From: Simon Davis
Sent: 01 February 2018 16:50
To: Planning.Responses
Subject: FW: 90 Rose Green Road AW/333/17/DOC

Further Drainage comments

Comments on revised proposals;

AQUACELL (MODULAR) ATTENUATION TANK DETAIL
(Scale 1:20)

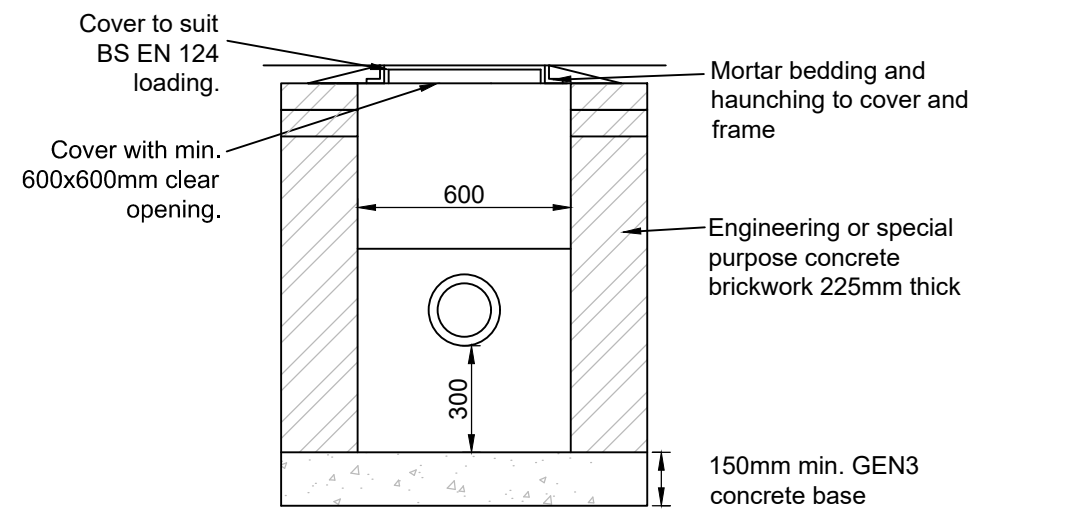
2. Make it clear that the 'modular system' is the crate storage tank.
3. Other components; specify more detailed frequencies for inspection/maintenance ie. not 'based on accessed flood risk'.
4. Include a brief description in the manual of how the drainage system is designed to work and include the management company arrangements, previously detailed by the developer.

CATCHPIT CHAMBER DETAIL
(Scale 1:20)

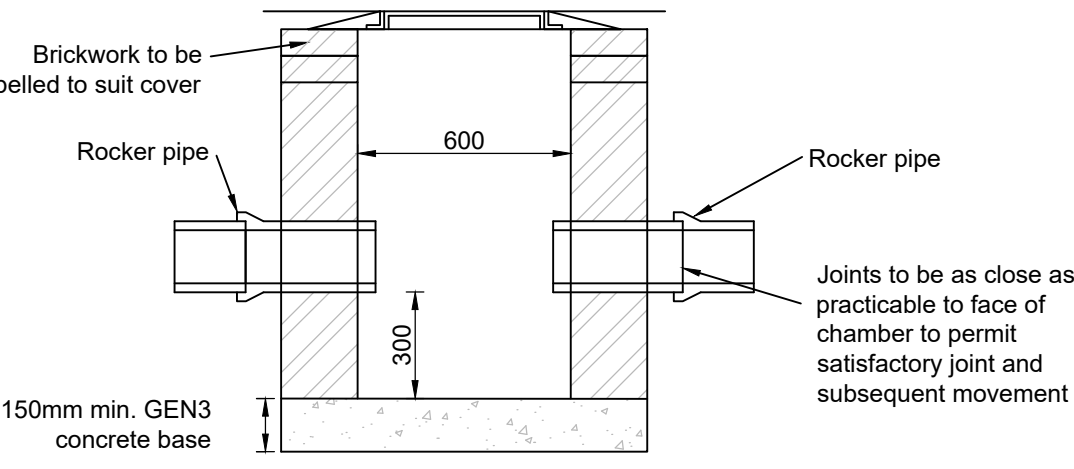
2. I await a copy of Southern Waters S106 connection approval.
3. Silt trap chambers to be min. 600x600mm internal dimensions with 600mm cover. Please adjust construction detail.
